Development Facilitation Team (DFT) – Review Comments

DRB Project No: PR-2022-007645 Date: 04/26/2023 Agenda Item: #4 Zone Atlas Page: J-10

Application For: SD-2023-00053-PRELIMINARY/FINAL PLAT (DHO)

SUBJECT: Preliminary/Final Plat

**Plat for
Lots 2-A, 2-B, and 2-C, Tract S-1
Atrisco Business Park, Unit 2
Being Comprised of
Lot 2, Tract S-1,
Atrisco Business Park, Unit 2
City of Albuquerque
Bernalillo County, New Mexico
March 2022**

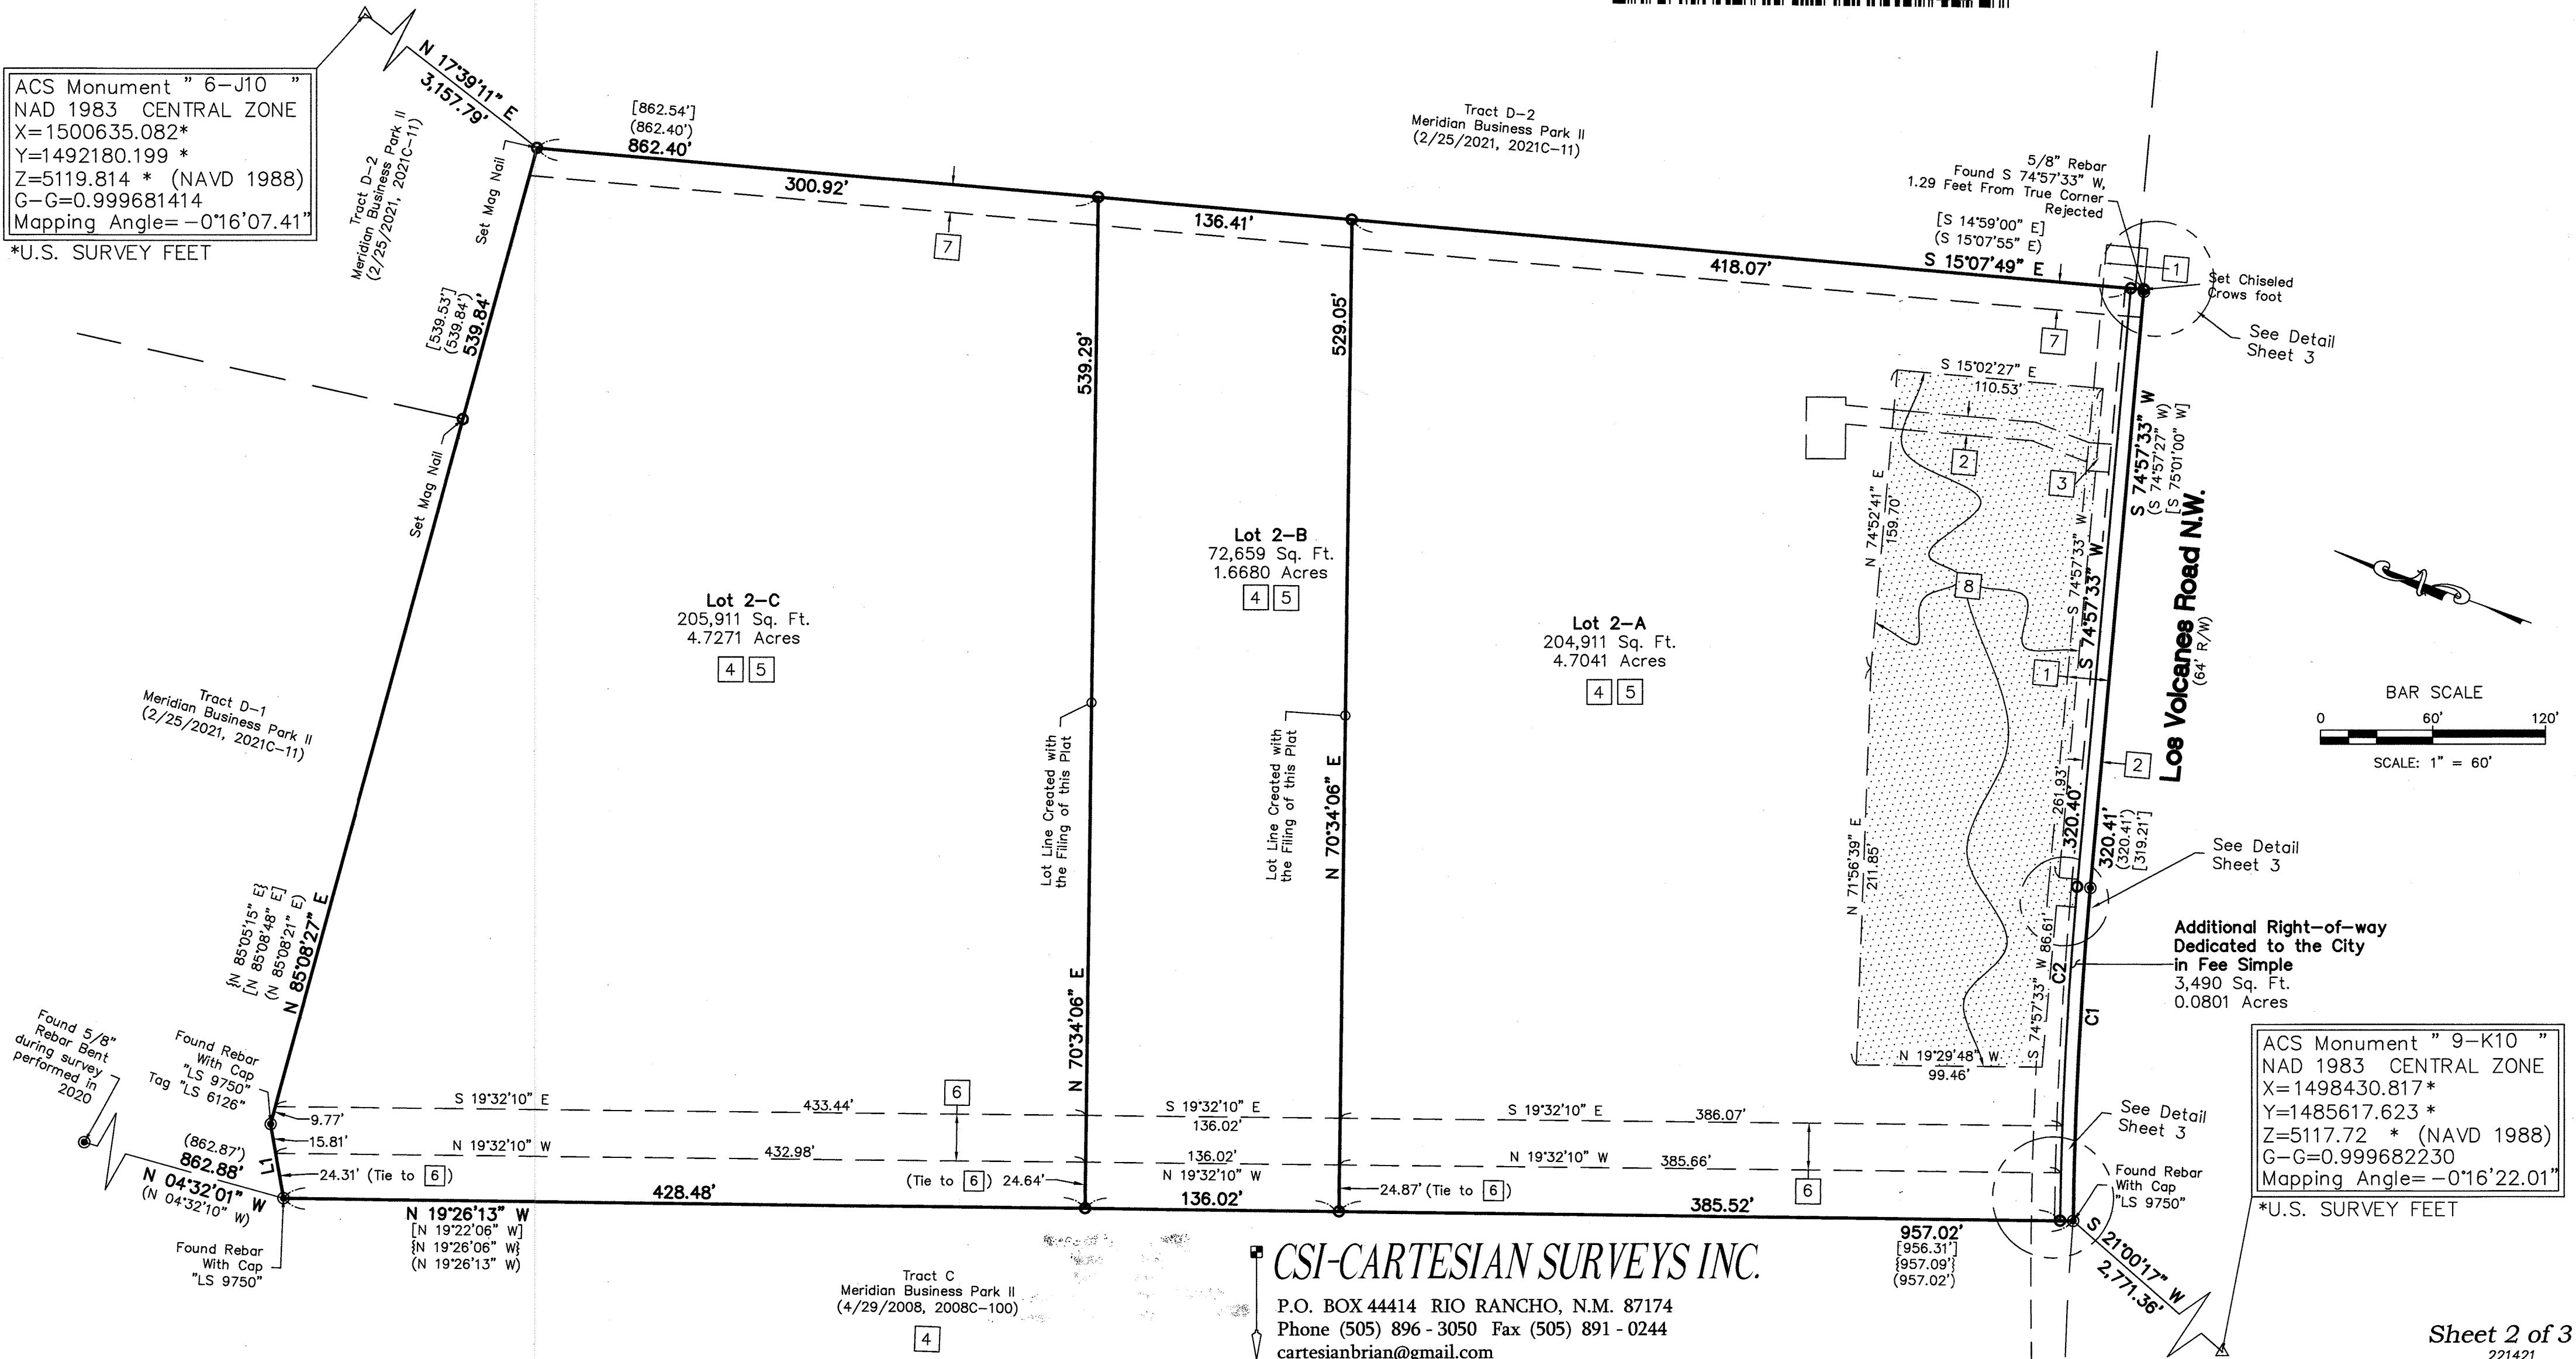
1. Justification for leaving sidewalks at 4' is not sufficient. A 6' sidewalk with a 5-6' landscape buffer is required.
2. For any future development, a Traffic Circulation Layout will be required prior to Building Permit or Site Plan for Building Permit.

- Hydrology has an approved Conceptual Grading & Drainage Plan (J10D027) with engineer’s stamp 02/21/2023.
- The existing detention pond needs to be in a private drainage easement **with the drainage easement notes** showing maintenance responsibility for all three lots.

1. Cross Parking access agreement is shown, but we need to confirm if the required parking for the existing structure is being compromised by the proposed re-plat, which would require a Shared Parking Agreement to be recorded. Submittal says Site Plan showing calculations was included, but I could not find it. Please show how remaining parking would meet existing parking requirements.
2. Code Enforcement needs to confirm if a Shared Parking Agreement needs to be recorded with the re-plat, before approving.
3. No further comments or objections.

- The project & application number must be added to the Plat prior to final sign-off by DFT staff, should the Plat be approved by the DHO.
- *Per Table 7.2.29 from section 7 of the DPM:*
Los Volcanes is a Major Collector. Requires a 6ft Sidewalk & 5-6ft landscape buffer.
**Please confirm compliance, or waiver request, or DHO determination request?*
- Once IL-infrastructure list is approved, the project will need to provide a financial guarantee to DRC?
- Please clarify if parking and landscaping if affected by replat?
Please confirm that parking and landscaping requirements are being met for the current site and if a shared parking agreement is a part of the new development?
